Ribble Valley Borough Council
By email

Your ref 3/2025/0845
Our ref DC/25/2791
Date 03-NOV-25

Location: The Village Hall Franklin Hill Brockhall Village Old Langho BB6 8HY
Proposal: Proposed demolition of offices and construction of replacement office building.

Drawing Title
Proposed Site Plan

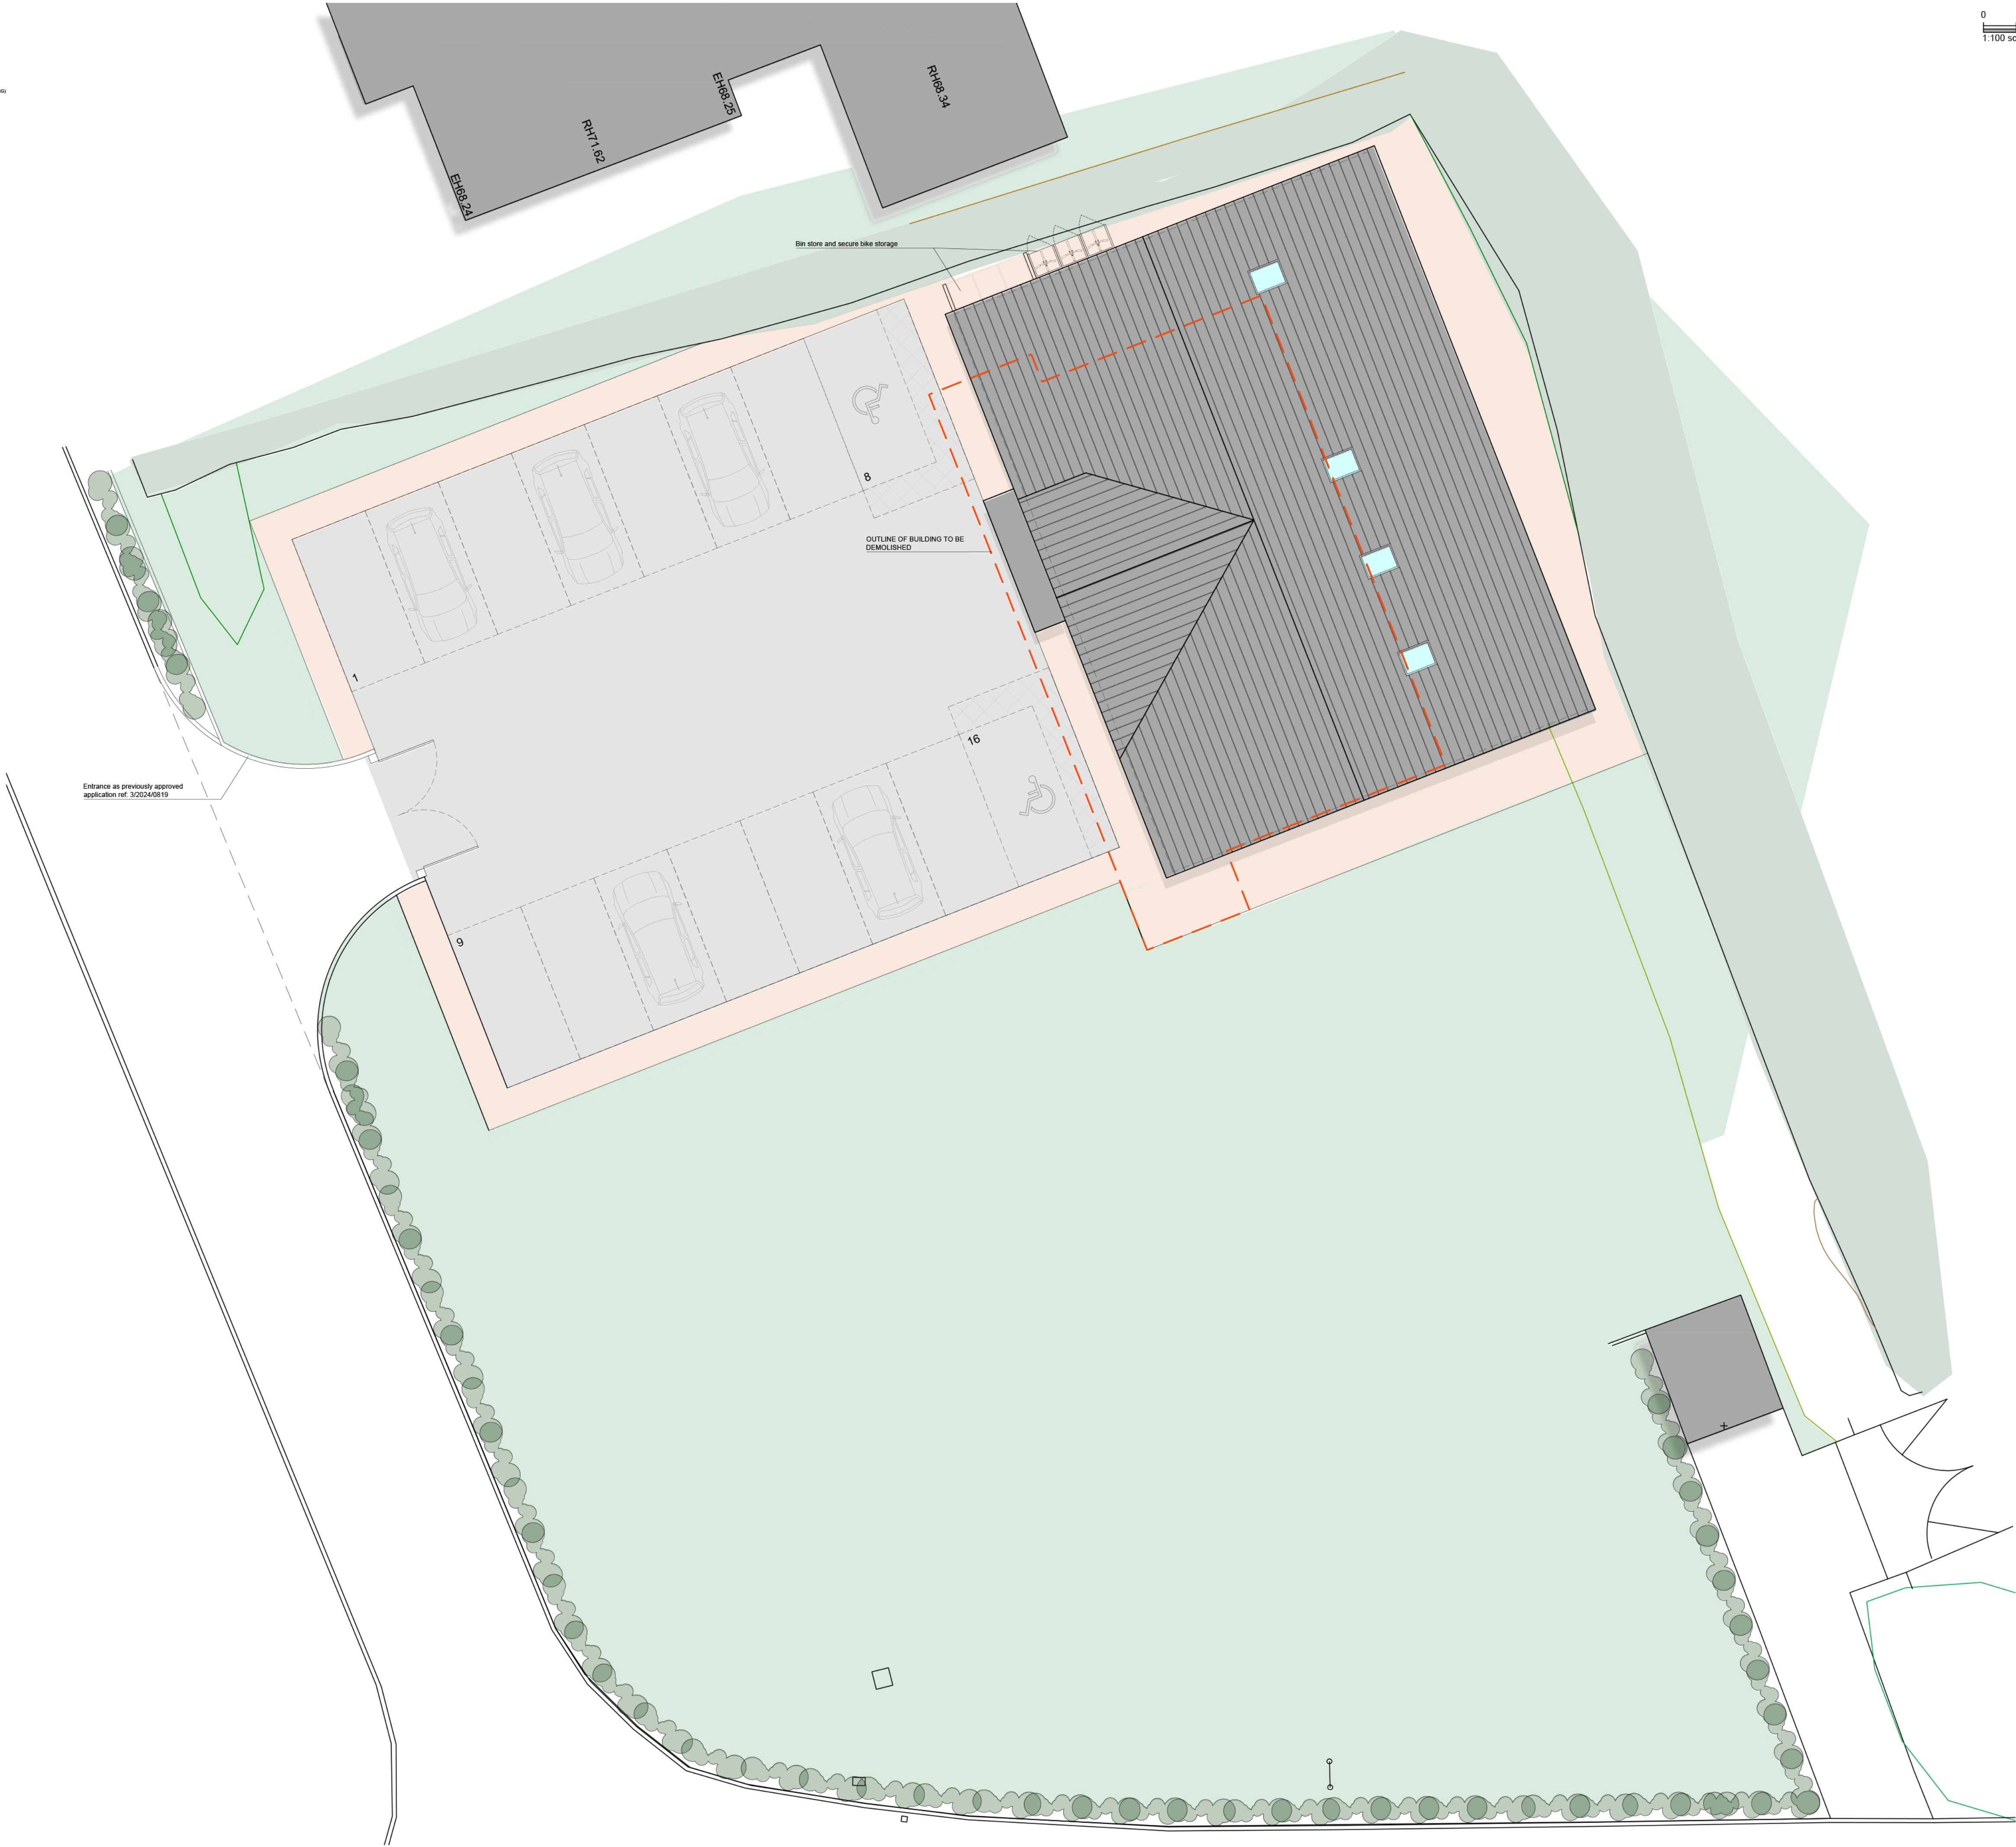
Noting this is a Full application, we request that the applicant provides a detailed drainage plan, and that United Utilities has the opportunity to review and comment on this plan PRIOR TO DETERMINATION of this application.

A water main is located at the entrance to the site. It must not be built over, or our access to the pipeline compromised in any way. We require an access strip as detailed in our 'standard conditions for works adjacent to pipelines', which can be found on our website: [working near our pipes - united utilities](#). The applicant must comply with this document to ensure pipelines are adequately protected both during and after the construction period.
